WST21/00002/05 SF2021/004875

**SSD-14540514: Review of Environmental Impact Statement - Wallerawang Battery Energy Storage System**

Figure 2-5 Base Year 2021 AM Peak Hour Traffic Volumes (update intersection labels to be consistent, add road names)

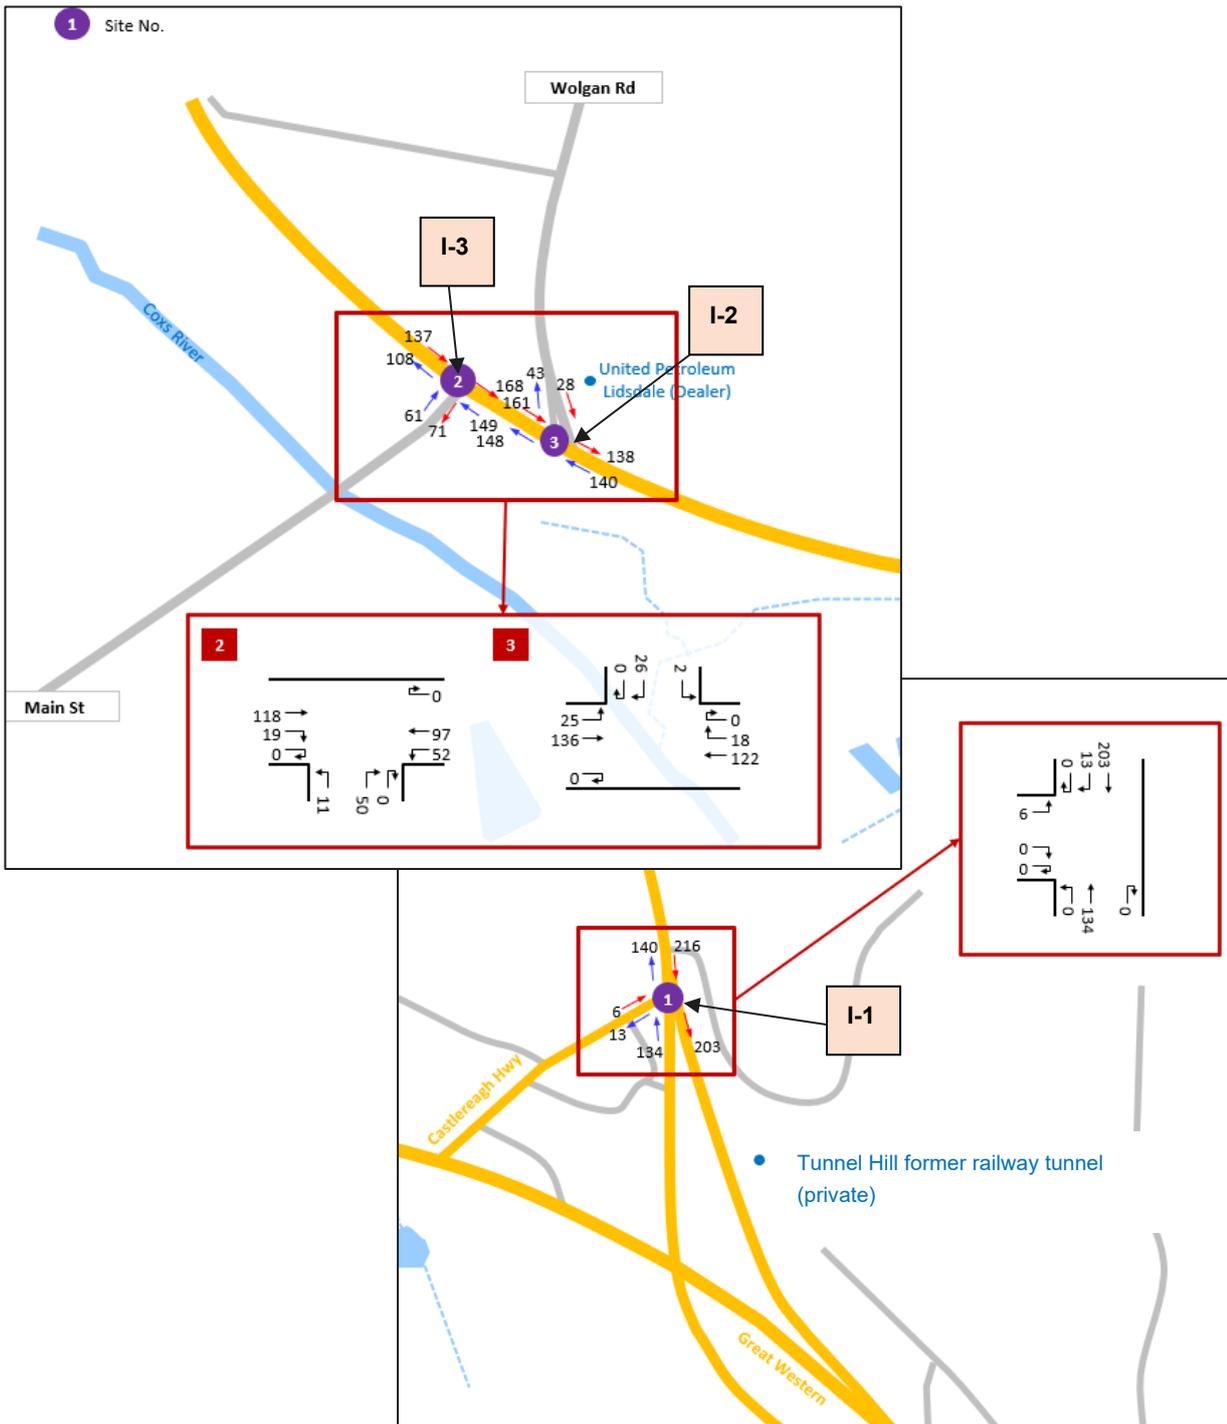
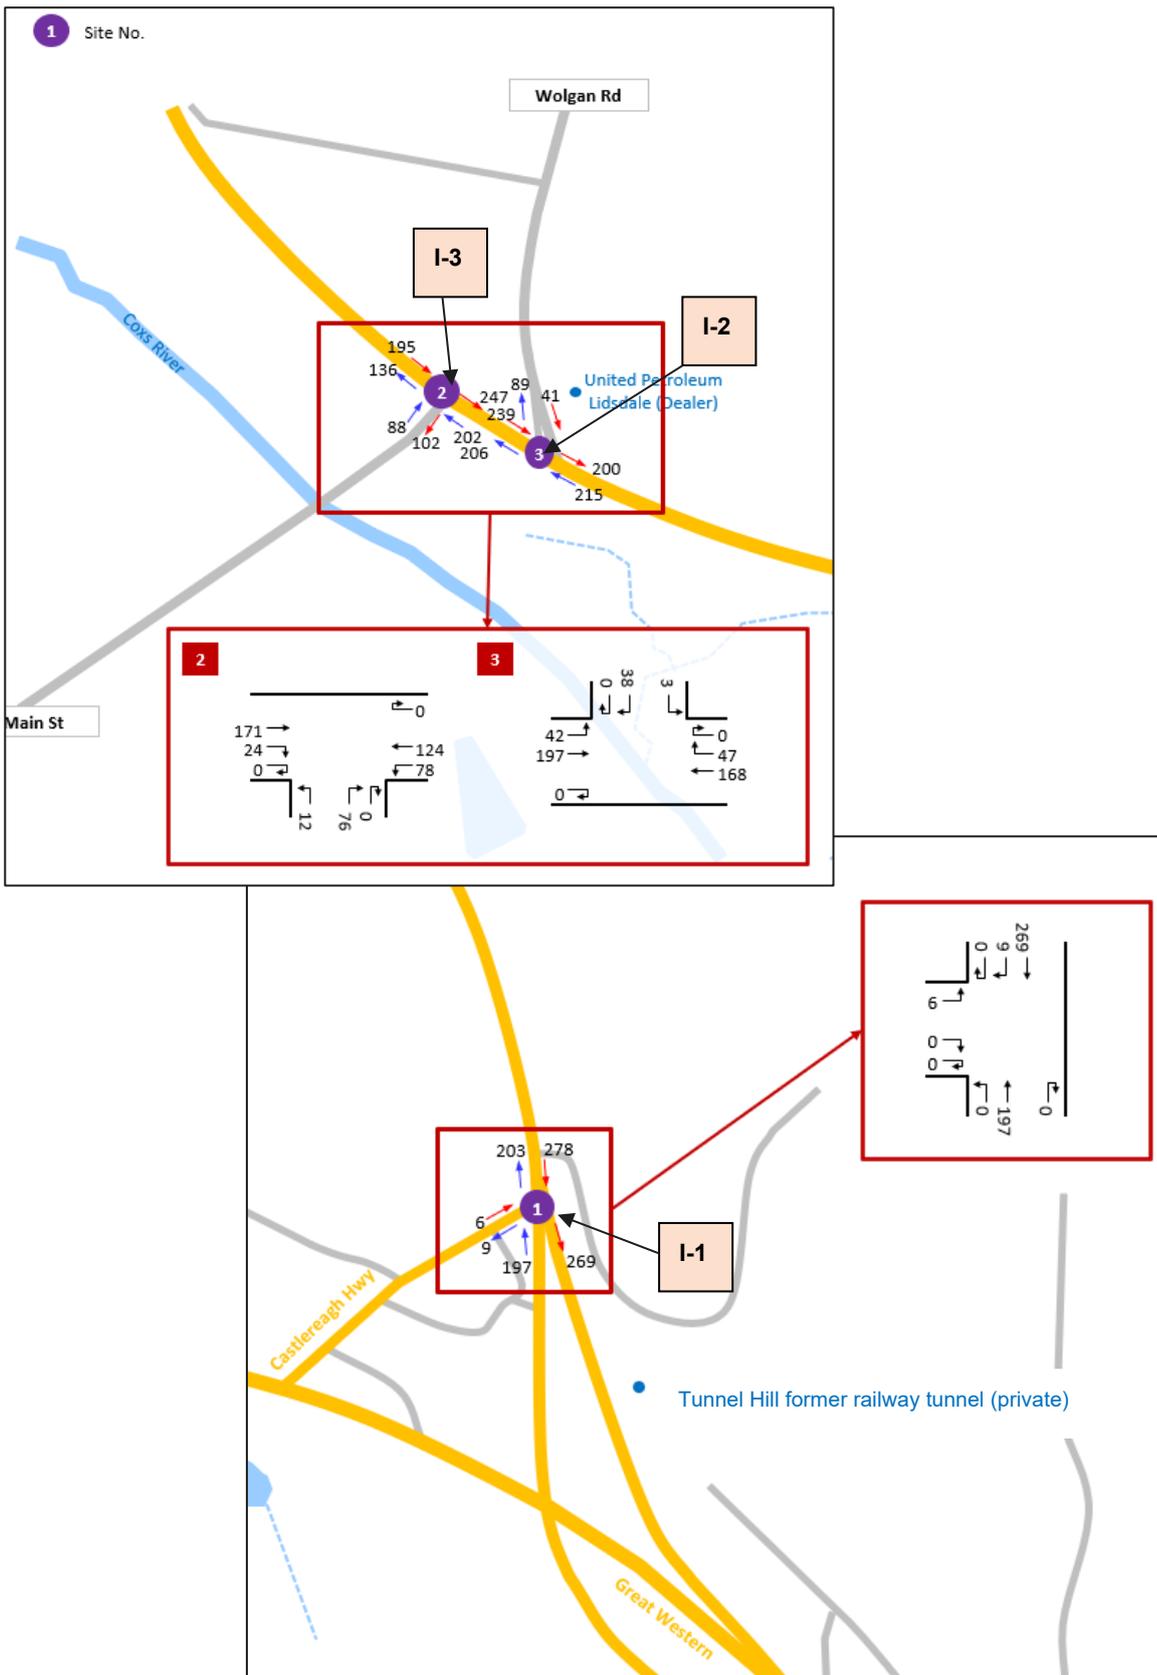
3. Clarification is required on the proposed routes to and from the site for construction vehicles.
4. The traffic counts and proposed peak periods provided (7:45-8:45am and 15:15-16:15pm) are based on counts from one day (30<sup>th</sup> March 2021), this is unacceptable. The TfNSW data referred to in Section 2.7.3 on the Castlereagh from the two-week period (25<sup>th</sup> May – 7<sup>th</sup> June 2021) showing AADT of 5420 vehicles should be utilised or traffic counts need to be undertaken over a seven-day period to improve the background traffic presented in the TIA. A full breakdown of traffic counts is required to clearly demonstrate peak periods.

Figure 2-7 Background Traffic Growth

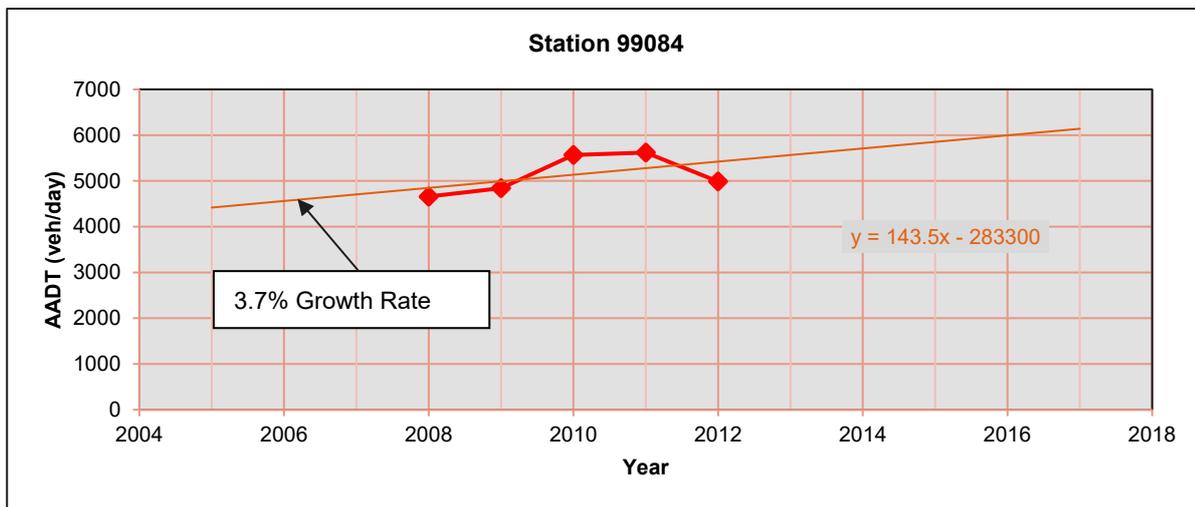
- Section 2.7.3 utilises the traffic volume viewer station (99084) for the background traffic. The traffic data from this station is from the year 2008 to 2012. The TIA suggests that a 3.7% growth rate has been adopted since the 2012 volume of 4988. Applying a 3.7% annual traffic growth rate since 2012 would equate to a 2021 AADT of 6918, this doesn't appear to be reflected within the TIA.

Table 4-7 Turn Lane Warrant Assessment –Construction year 2022 AM Peak hour conditions

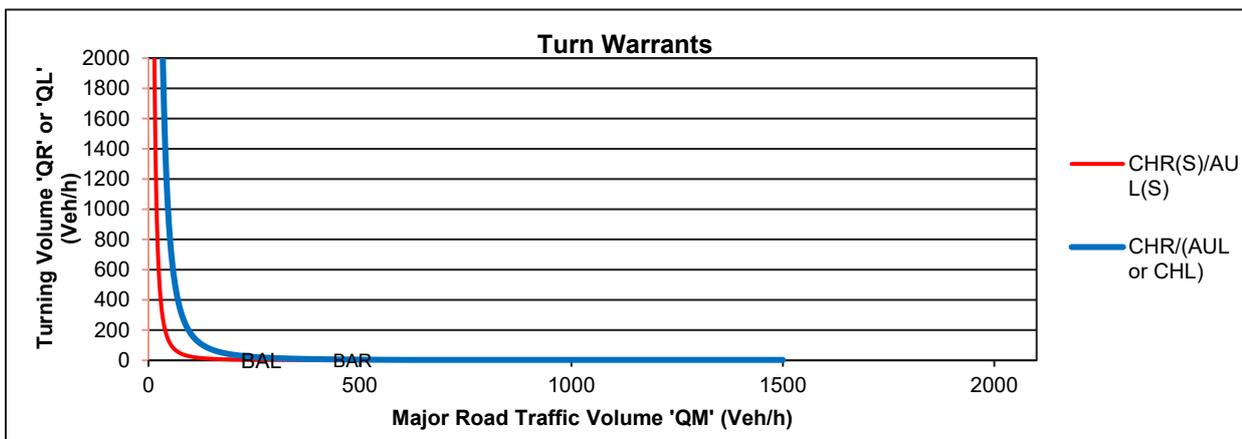
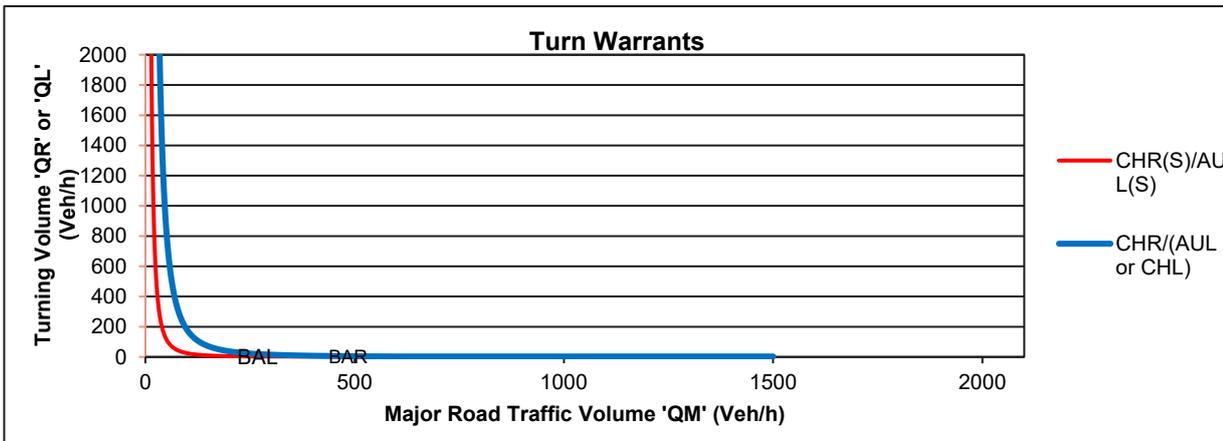
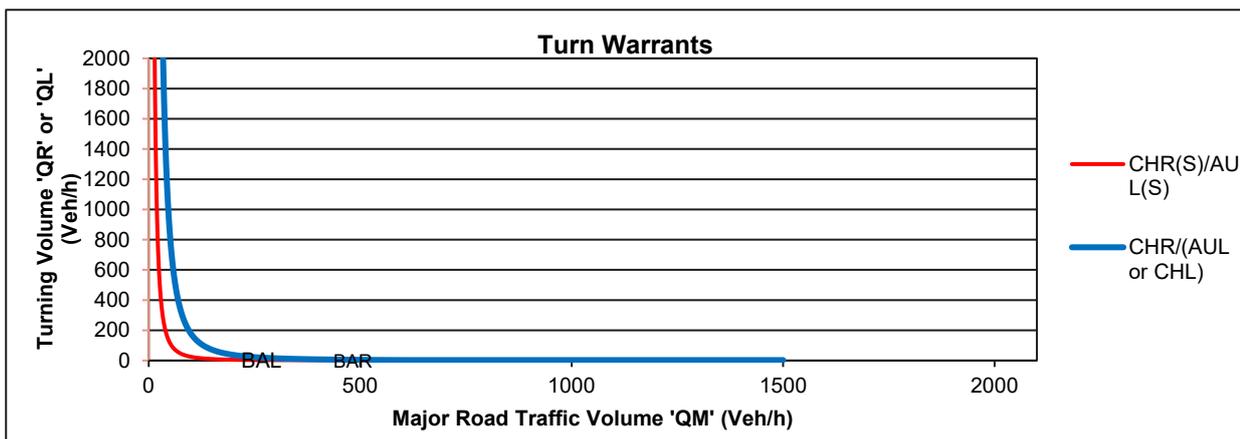
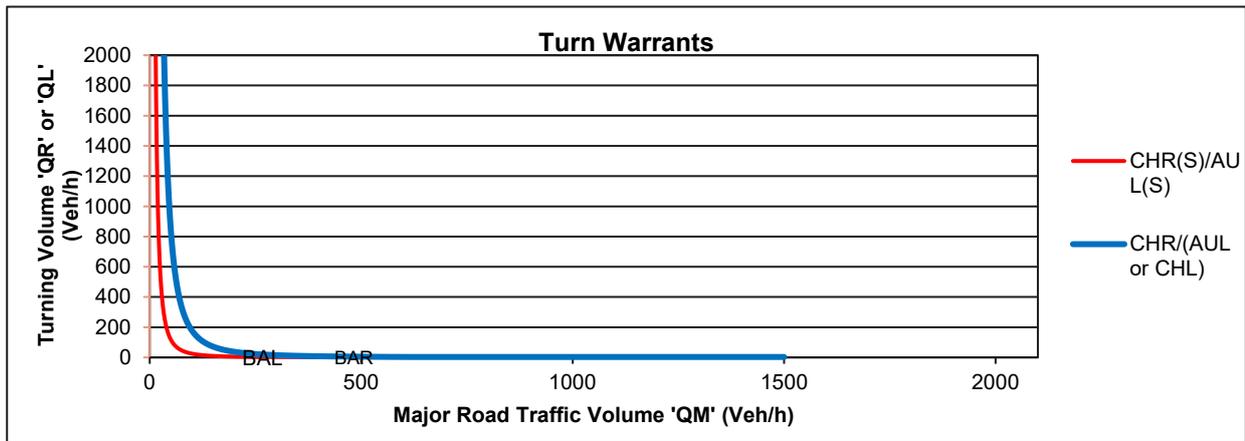
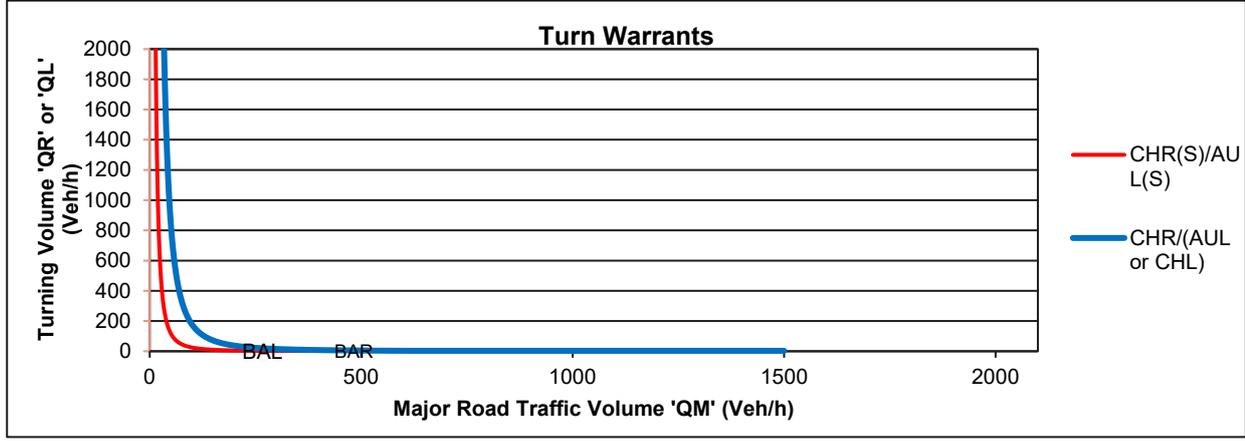
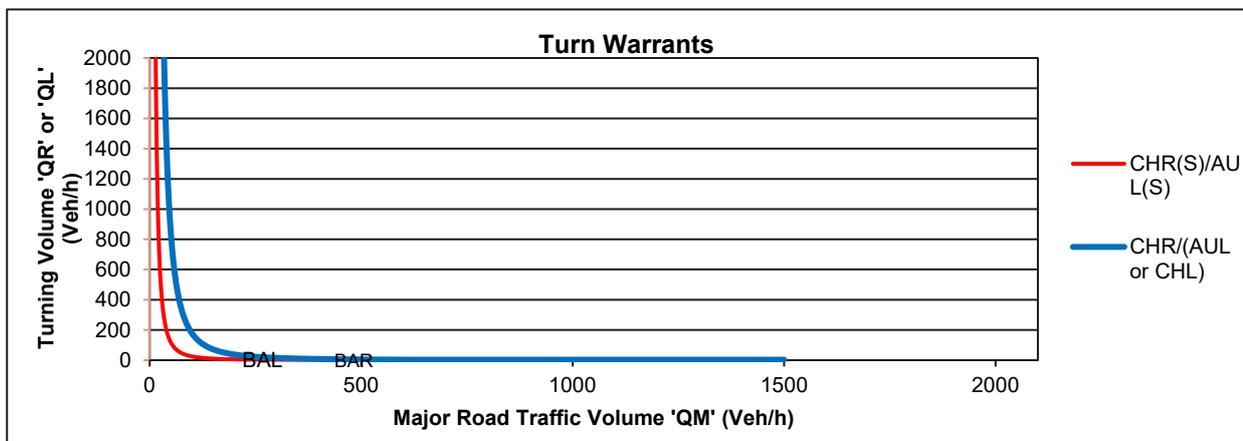
5. The turn warrant assessment shown in Section 4.1.3.1 need to be updated with amended traffic volumes and demonstrating a worst-case scenario as per the above comments. Refer to Austroads Guide to Road Design (AGTRD) Part 6: Intersections, Interchanges and Crossings Management (Figure 3.25).

Figure 4-5 Concept of Safe Intersection Sight Distance (SISD)

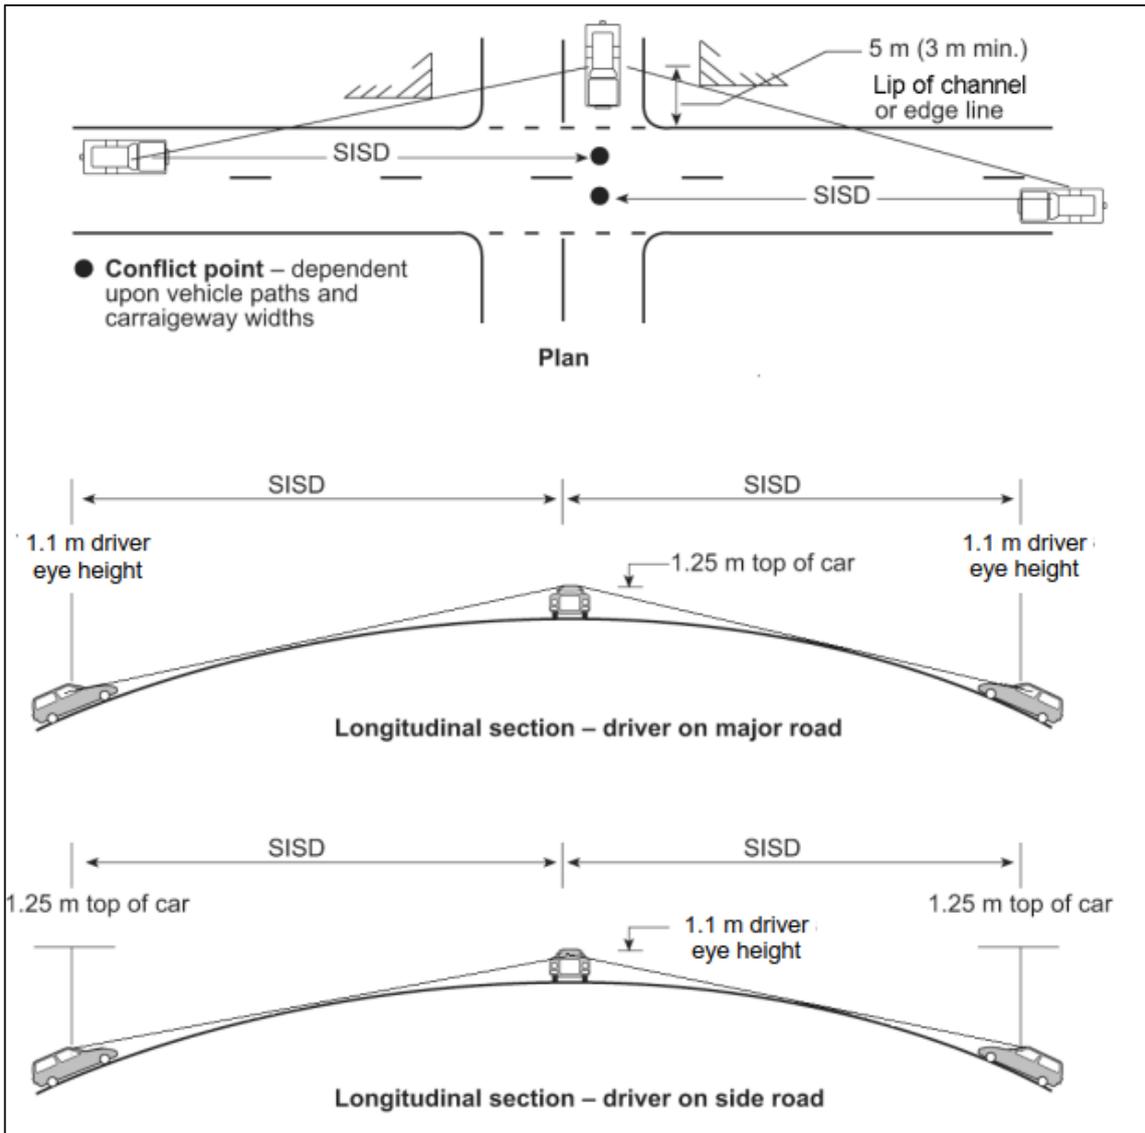
1. Following a site visit TfNSW raises concern regarding available sight distance approaching the site from the south. Scaled plans are required to demonstrate sight distance is available at the proposed access to the Castlereagh Highway, a design speed of 110km/h needs to be adopted (refer to Table 3.2 of Austroads Guide to Road Design Part 4A). Sight distance diagrams need to be provided using an eye height of 1.1m and a vehicle height of 1.25m showing the sight distance available both horizontally and vertically in accordance with Fig 3.2 Austroads Guide to Road Design Part 4A. Where landscaping and/or fencing is proposed along the property boundary, the plan must demonstrate the landscaping and/or fencing will not compromise sight distance.
